4-Way Ranch Commercial Master Traffic Impact Analysis (LSC #S224450) September 20, 2022

LSC Responses to 4-Way Ranch Commercial TIA Redline Comments

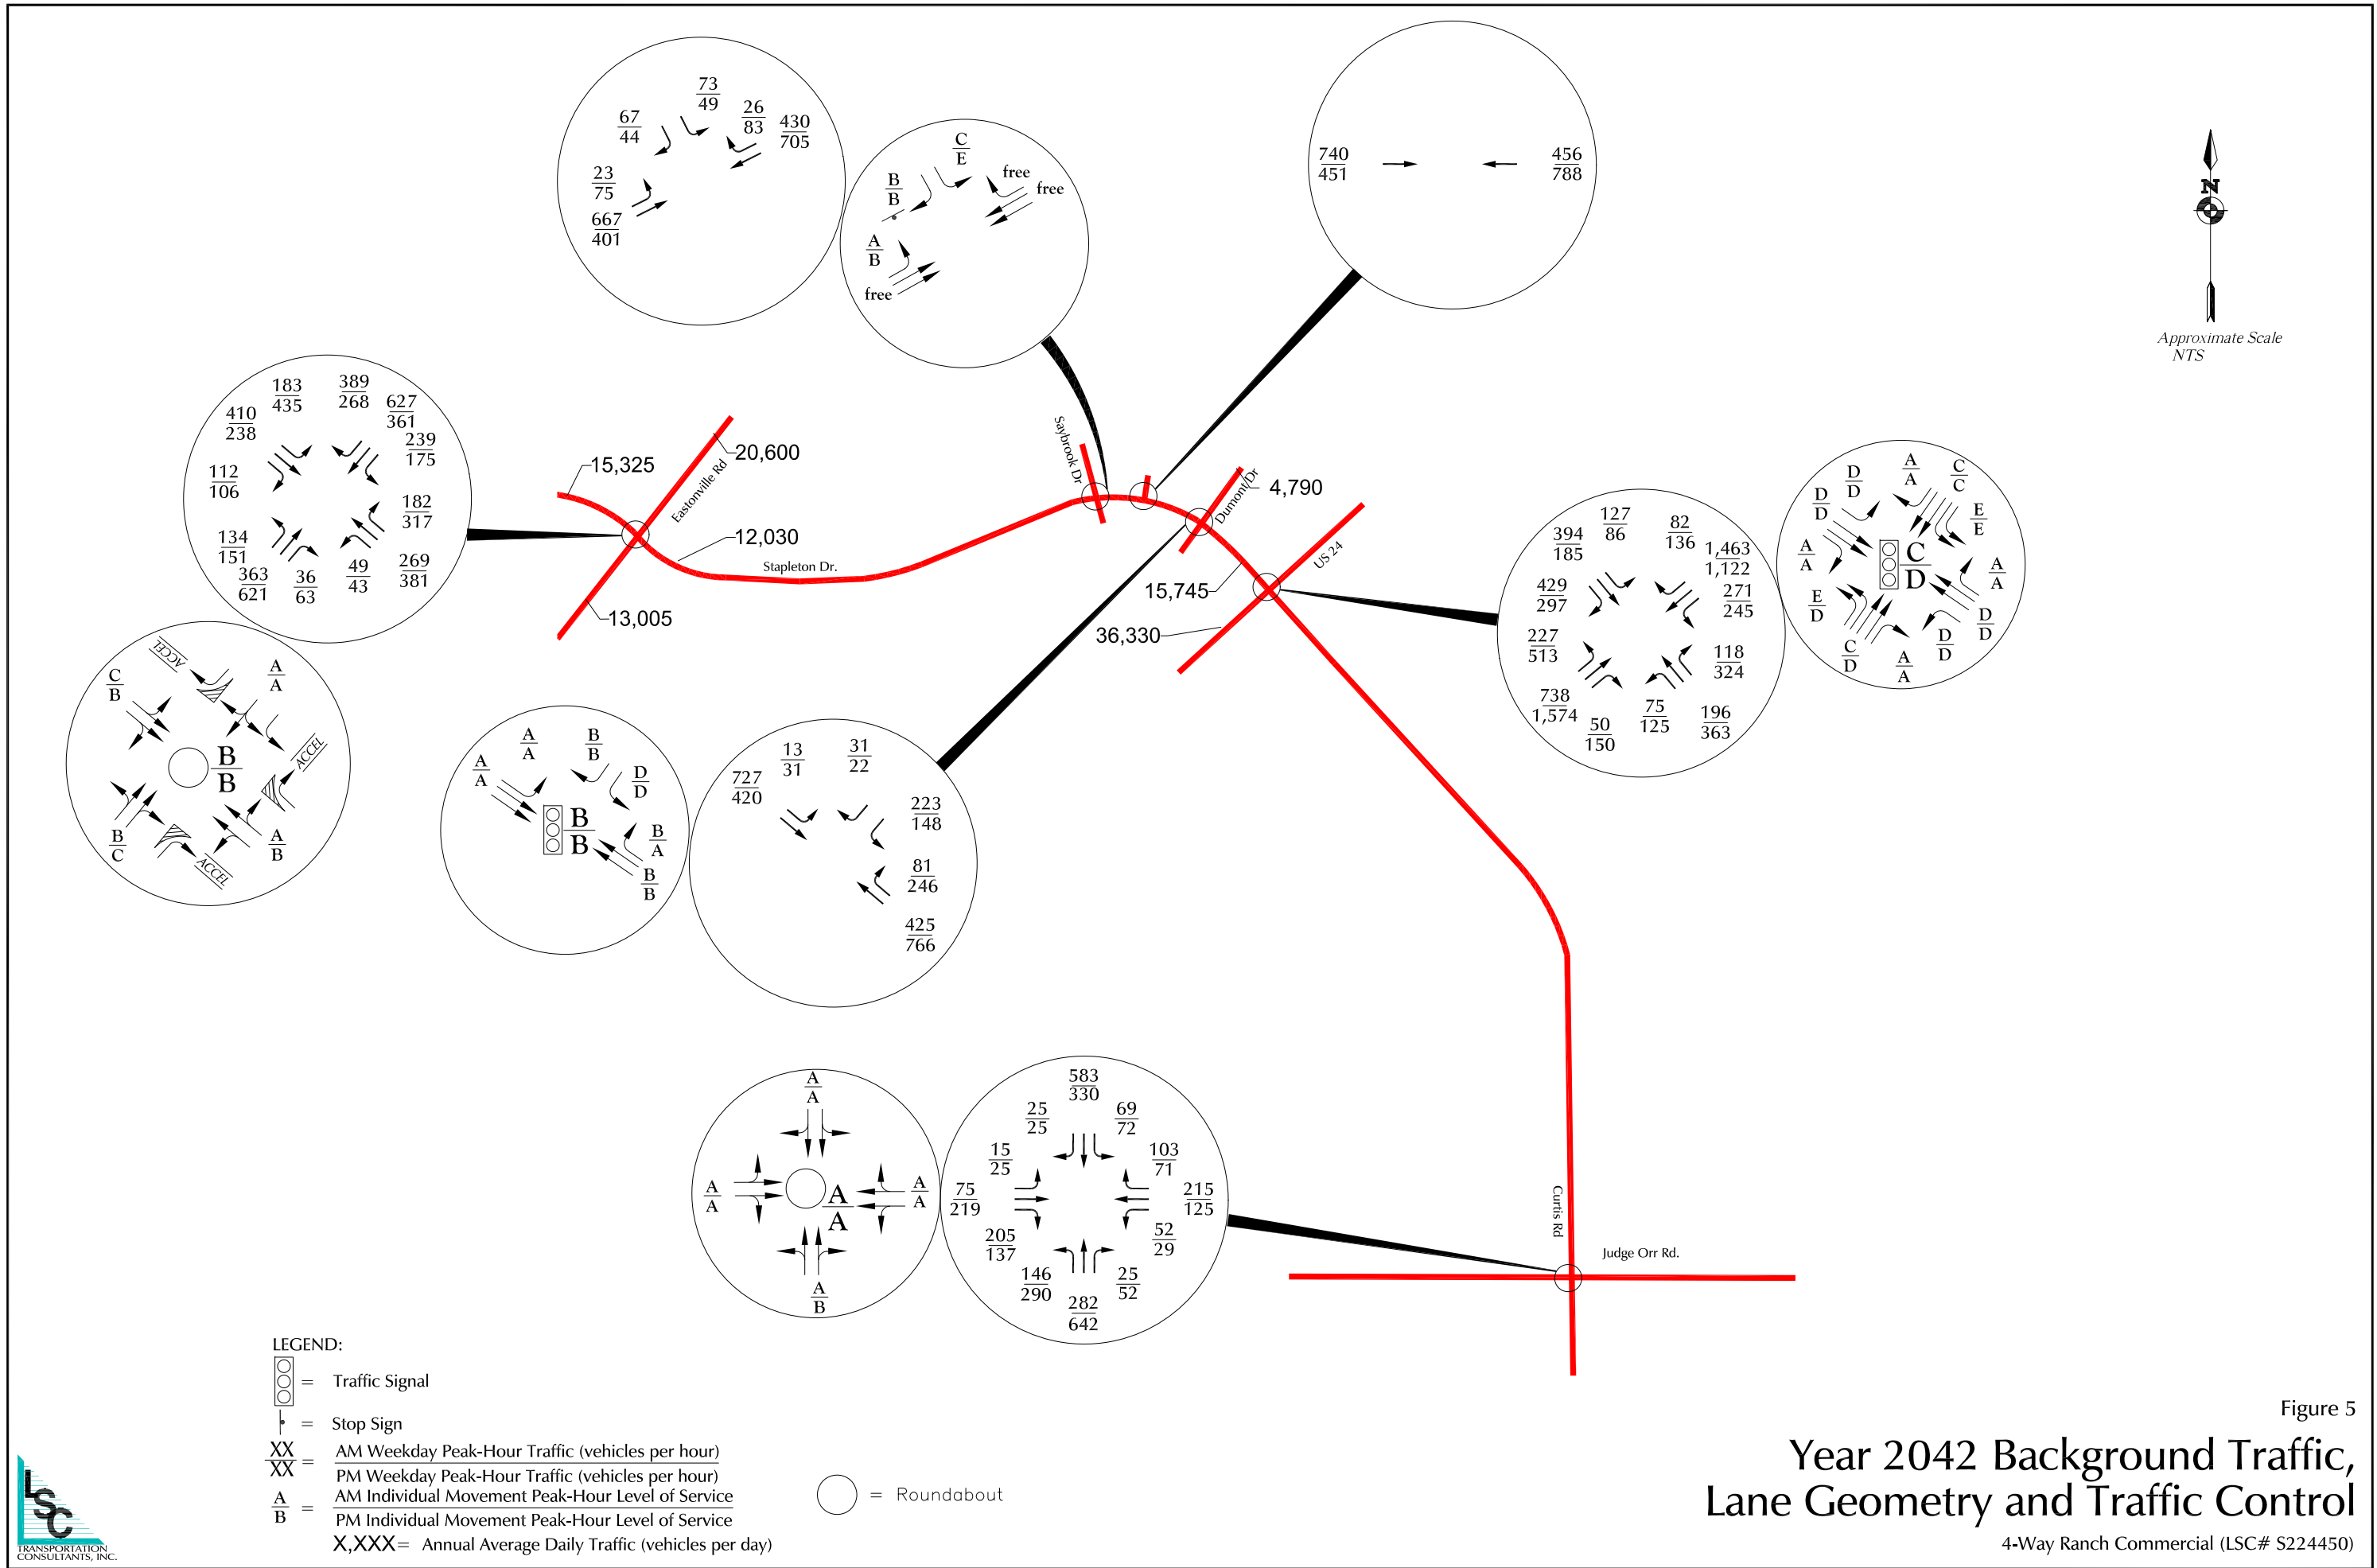
[Show stop signs on plan \(All figures\)](#)

[CDOT has a 2021 count](#)

[Use a different symbol for roundabout. Easily confused with circle indicating intersection \(all Figures\)](#)

LSC Response: The stop signs are shown in the bubbles with the lane geometry and LOS.

LSC Response: The AADT volume on US 24 has been updated to the 2021 count data.

LSC Response: The symbol has been revised as requested.

Directional Distribution of Site-Generated Traffic

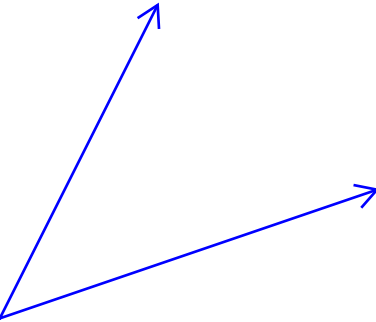
[Why are counts negative?](#)

LSC Response: The negative numbers are reflective of the passby trip assignment. The passby trip assignment has been completed in accordance with ITE "Trip Generation Handbook, Third Edition" Section 10.5.1. Figure 10.2 of this publication shows an example of the passby volume adjustment and negative trips.

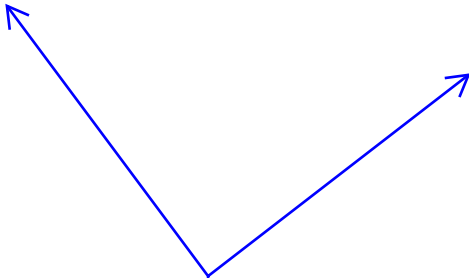
[Remove north leg as it's not part of the short term analysis](#)

[Should these 2 volumes add up to the 2606?](#)

LSC Response: The figures have been updated as requested

LSC Response: 1% of the trips are projected to travel to/from the Waterbury development to the north. Additional ADT locations are shown on the updated figures.

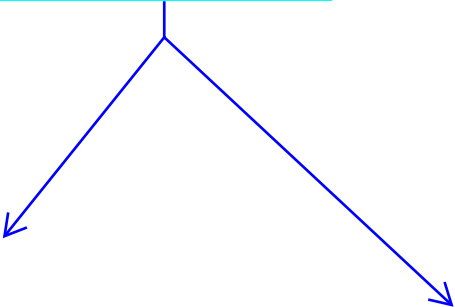
[Should these 2 volumes add up to the 11143?](#)

LSC Response: 1% of the trips are projected to travel to/from the Waterbury development to the north. Additional ADT locations are shown on the updated figures.

Figure 9
2026 Total Traffic, Lane Geometry and Traffic Control
 4-Way Ranch Commercial (LSC# S224450)

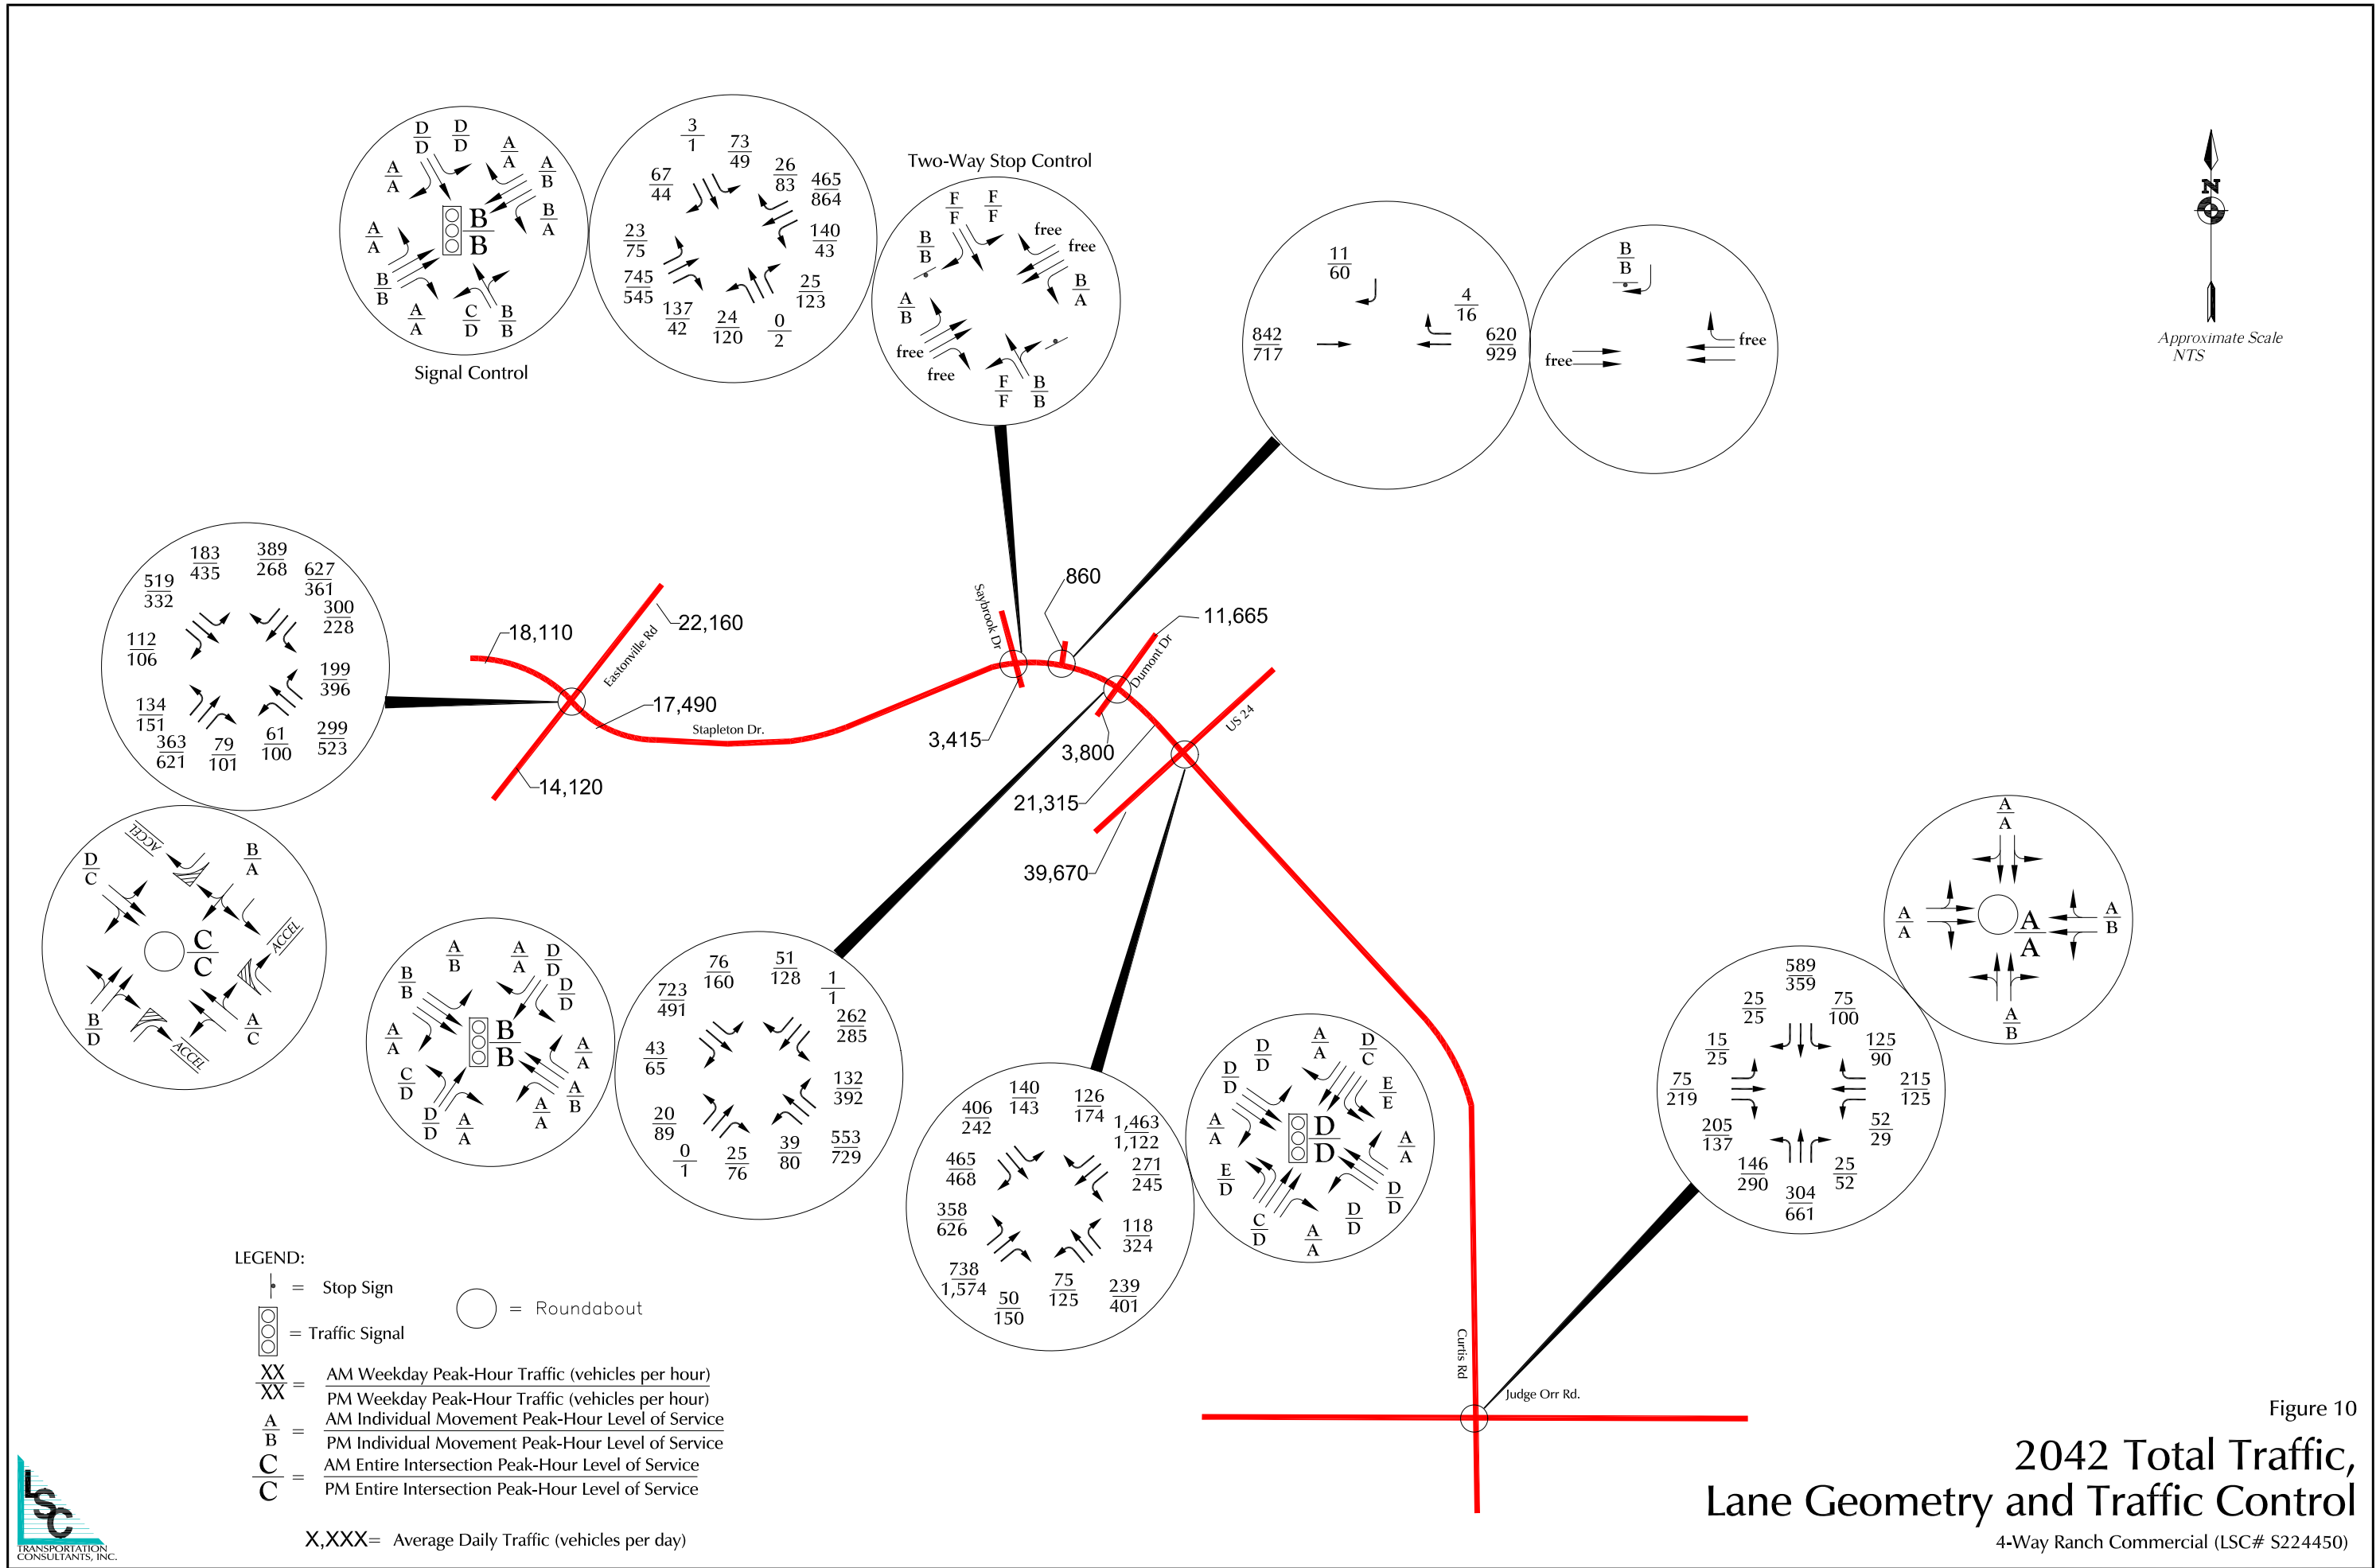
[I did not get this volume. Please verify](#)

[Remove north leg as it's not part of the short term analysis](#)

[Why are the counts from Figure 7 not shown for these 2 intersections?](#)

LSC Response: The volume has been revised

LSC Response: The figures have been revised as requested
